Administrative Authorization Application

PROJECT NAME: JONES RICH + HUTCHINS - FUNERAL HOME - BODY COOLER ADDITION

PROJECT ADDRESS: 199 WOODFORD ST. CHART/BLOCK/LOT: 130-F-6

Jean Fraser - 199 Woodford Street - Body cooler addition

DRAWING TITLE <b>Site Plan</b>	
DATE <b>July 13, 2011</b>	
REVISIONS NO. REVISION & DATE NO. REVISION & DATE NO. REVISION & DATE	
SCALE <b>AS NOTED</b>	
SHEET NUMBER <b>A0.2</b>

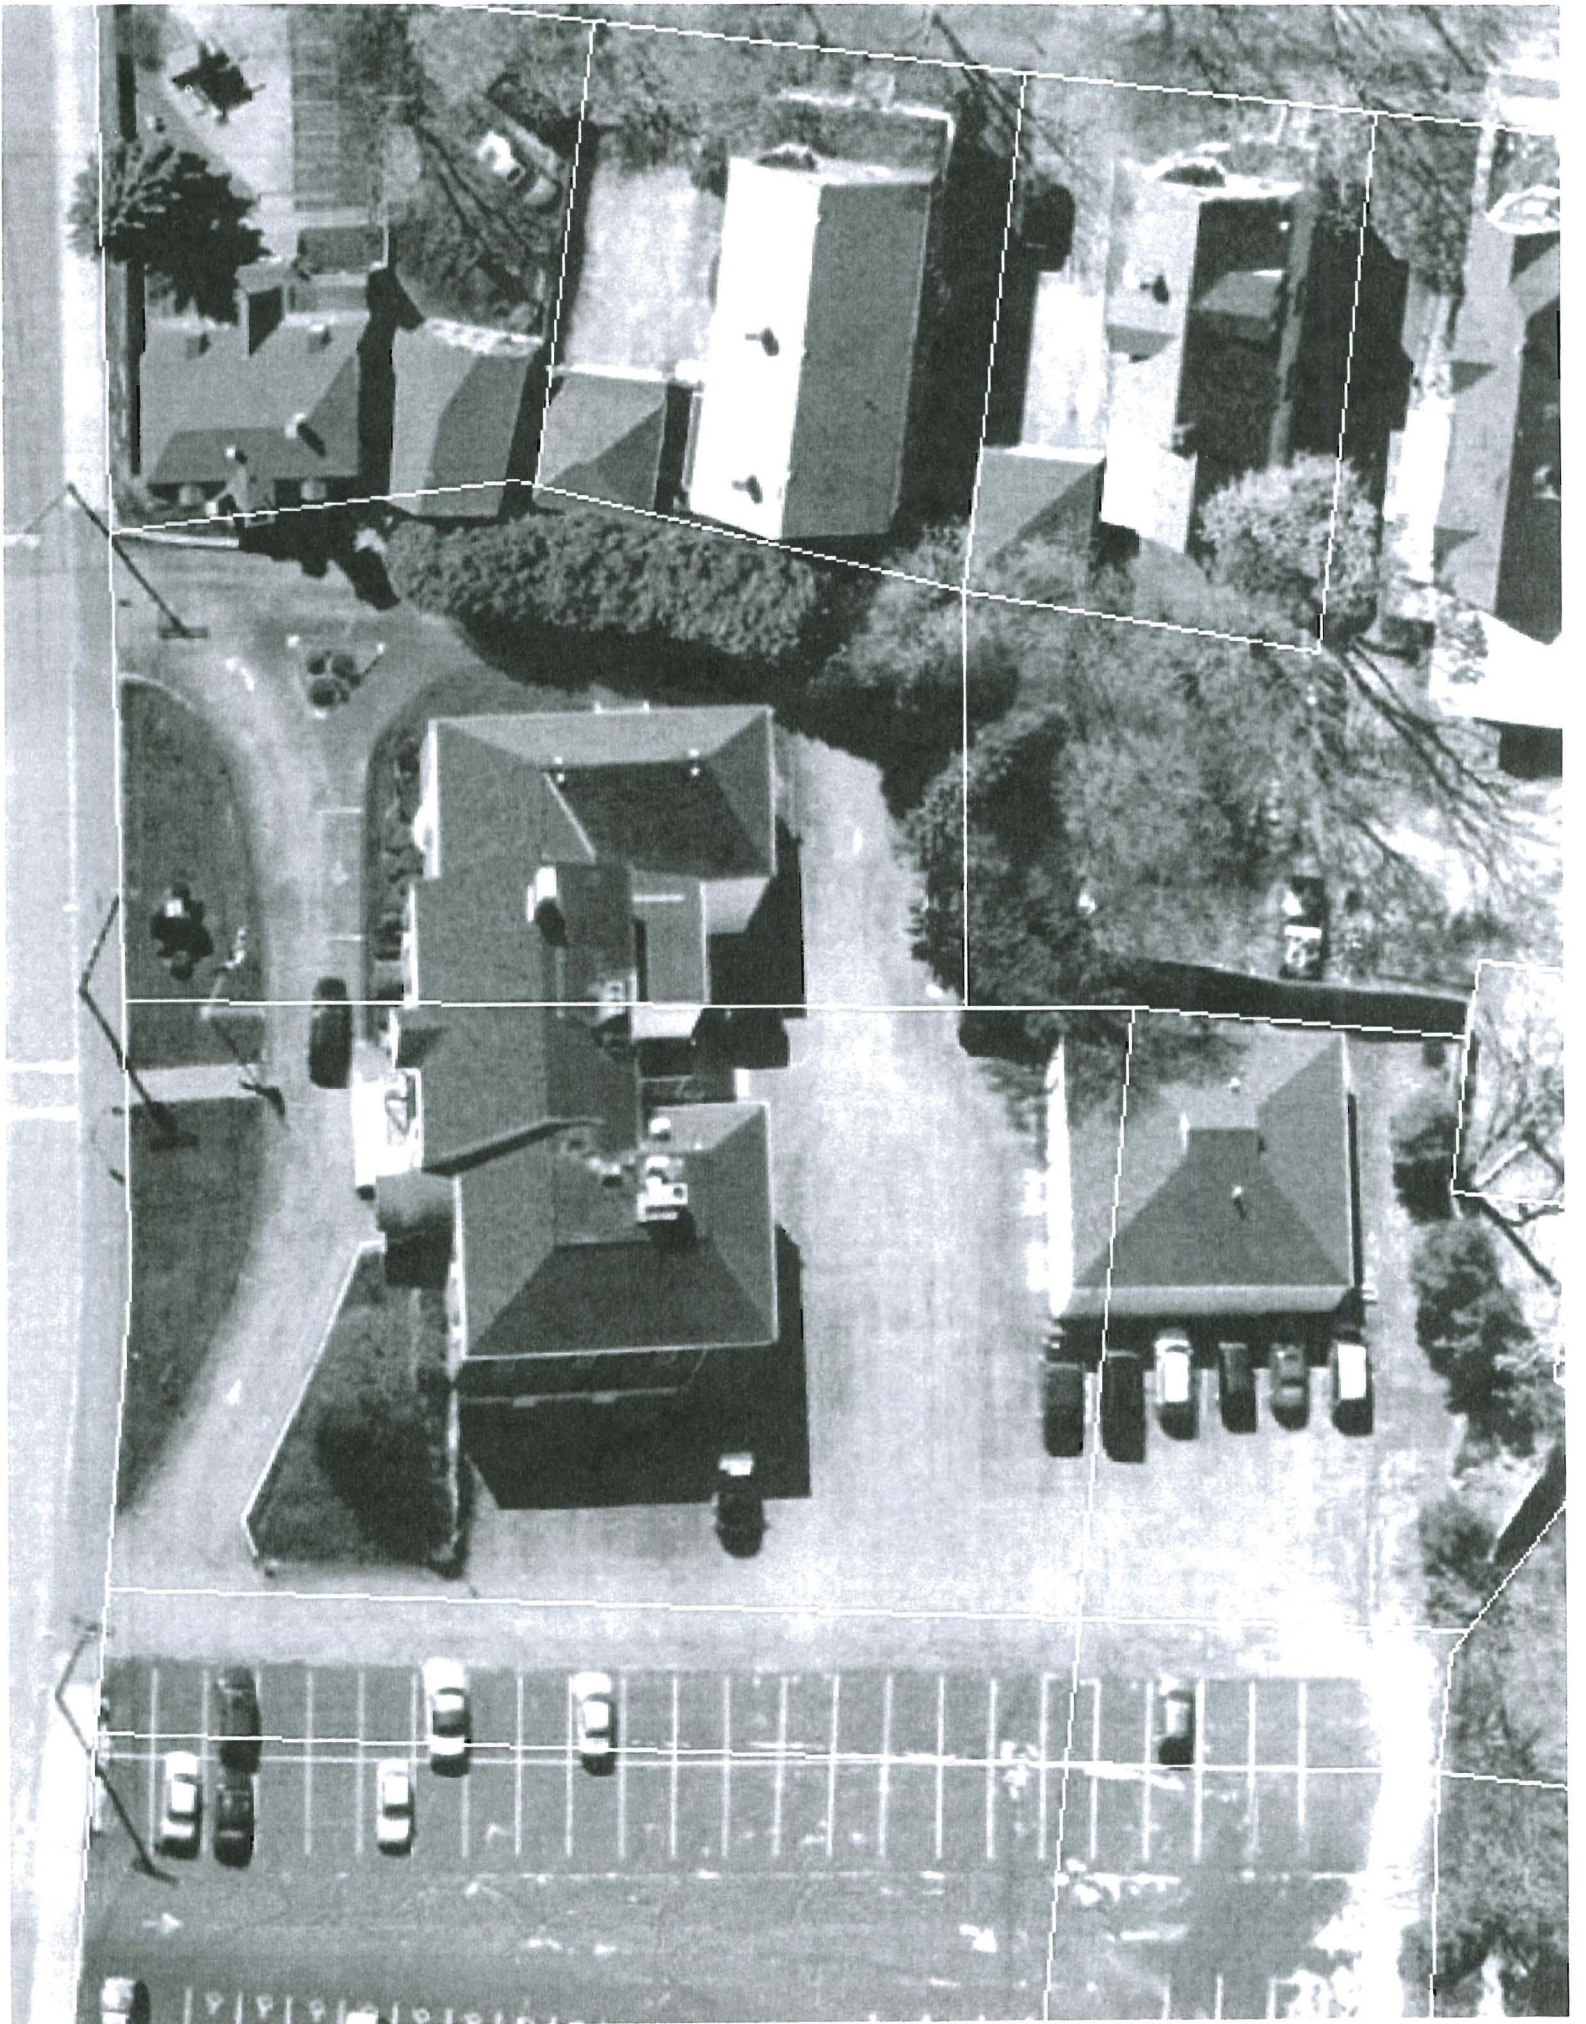
1. site plan showing the cooler, scaleable, showing lot boundaries; and
2. clarification of storm drain links; and
3. sound generation information from the manufacturer.
